ROLLING HILLS BOOSTER PUMP STATION SMALL SUBDIVISION DRAINAGE REPORT

(THE HILLS AT LORSON RANCH FILING NO. 1)

Add PCD File #
PPR-21-075

DECEMBER 2021

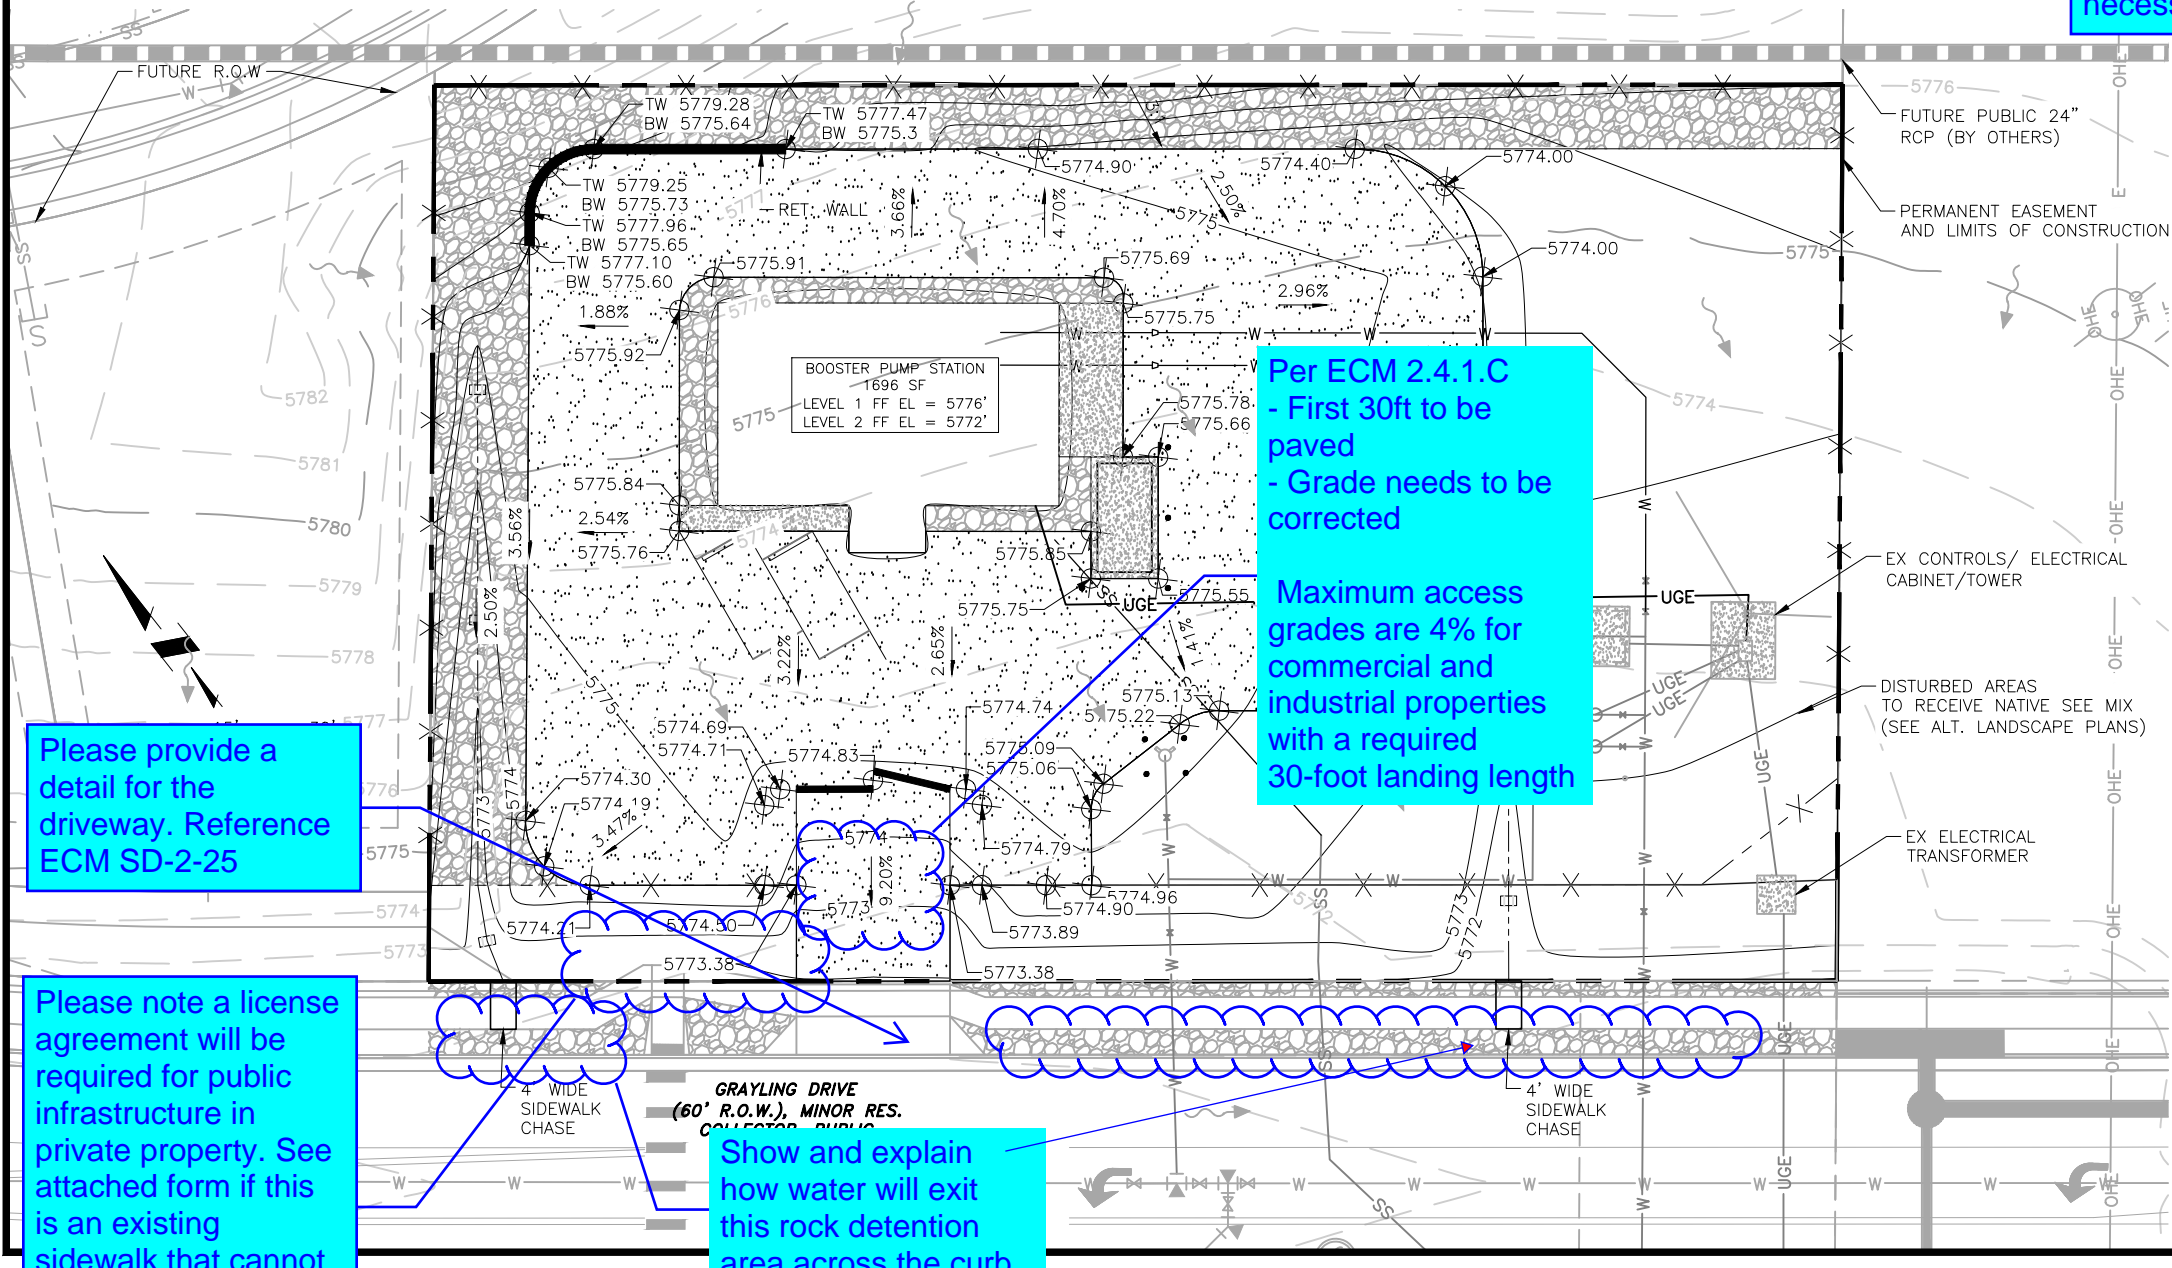
Sidewalk chases are not recommended due to maintenance requirements. Recommend conveying site flows to rear and connect to RCP flowing to Pond C-3
